SUBJECT: SFD2107-0046
SINGLE FAMILY DWELLING

Here are the results of all Inspections located at **1175 COBB RD:**

A101

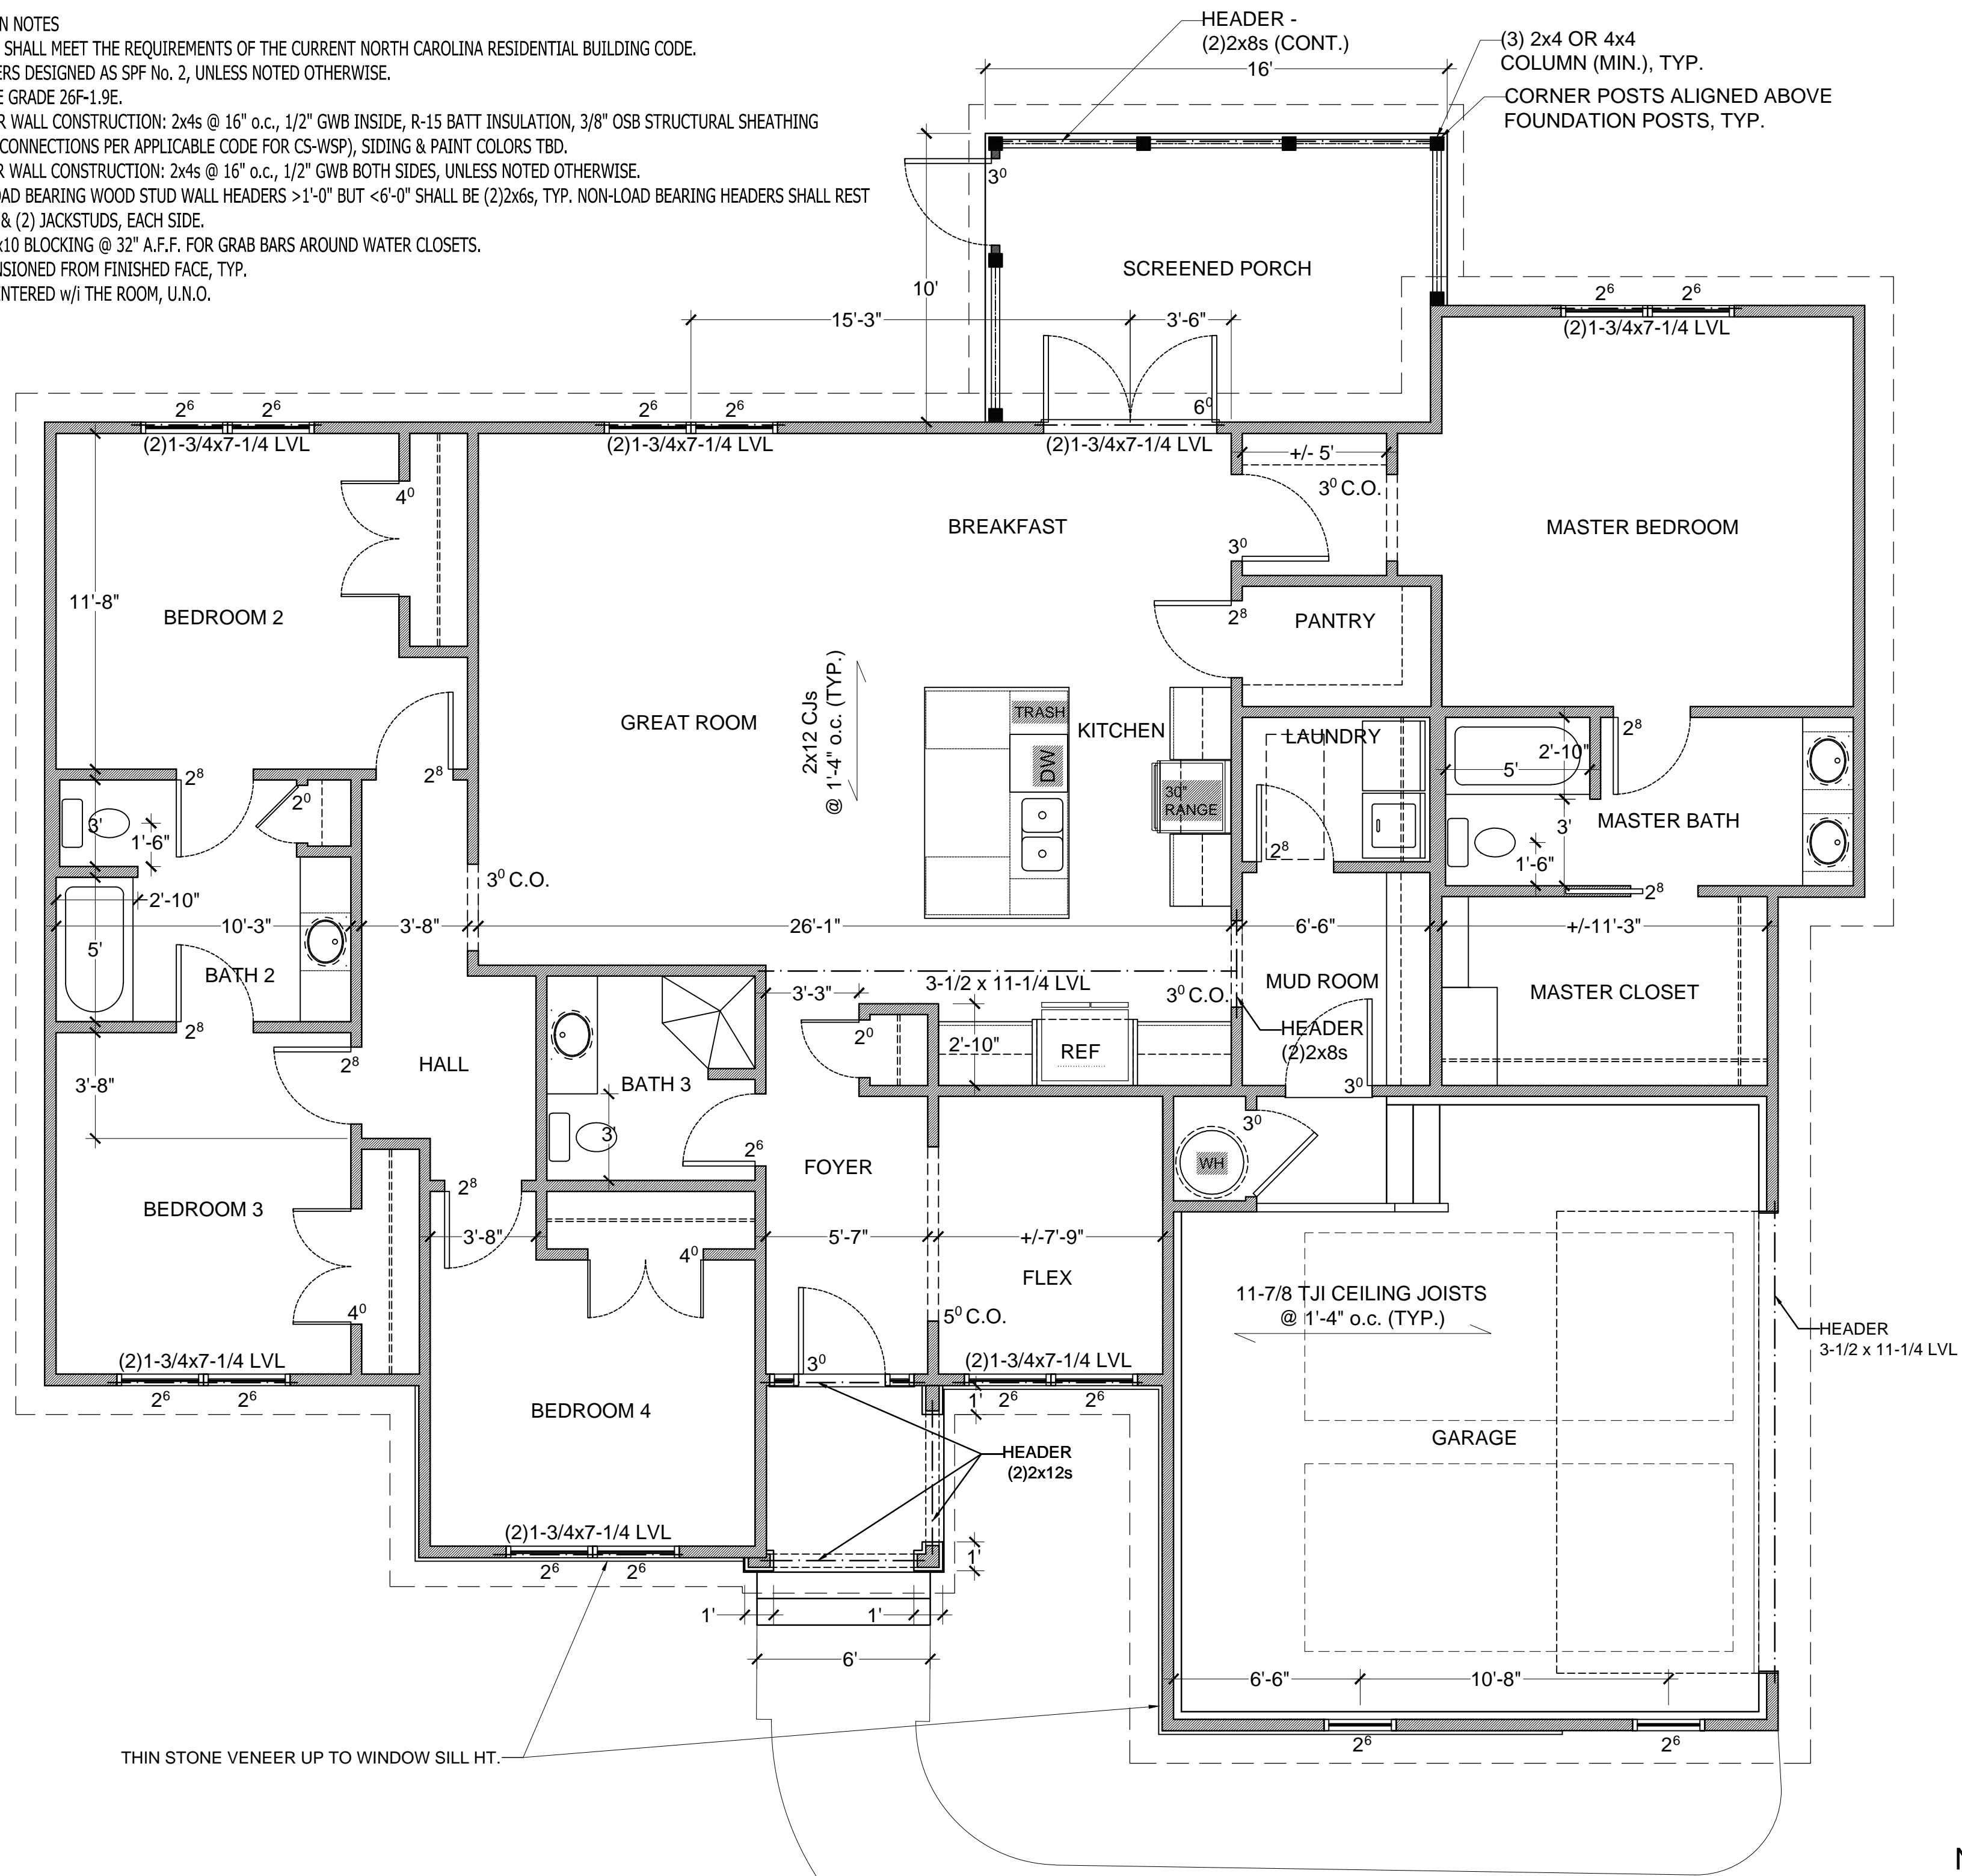
1. Missing missing anchor, bolt, right side of portal frame, and garage wall
2. Left window, king stud needs to bare, solid, and garage
3. Anchor bolts need to be in the center 1/3 entire garage

4. Right side of interior garage door needs to have two straps 24 inches because of the brake is less than 24 inches
5. Water psi test was low
6. Need to seek subfloor in master

7. Missing exhaust fan at master water closet.
8. Missing nail guard on 12 to wire left of rear door
9. Missing strap on 4 sc front left bedroom
410. Bedroom 4 closet missing stud max 24"

11. DWV no water test
12. Missing jack at front door .
13. Missing anchor bolts at front porch area all of them
14. Missing hangers at LVL for ceiling joist

15. LVL triple LVL needs to be fastened per code got a big gap
16. Double 2 x 12 in master where rafters are landing on, need to get information to say that it meets code
NOTES
House was sided at the time of inspection
Going to have deck on rear at some point
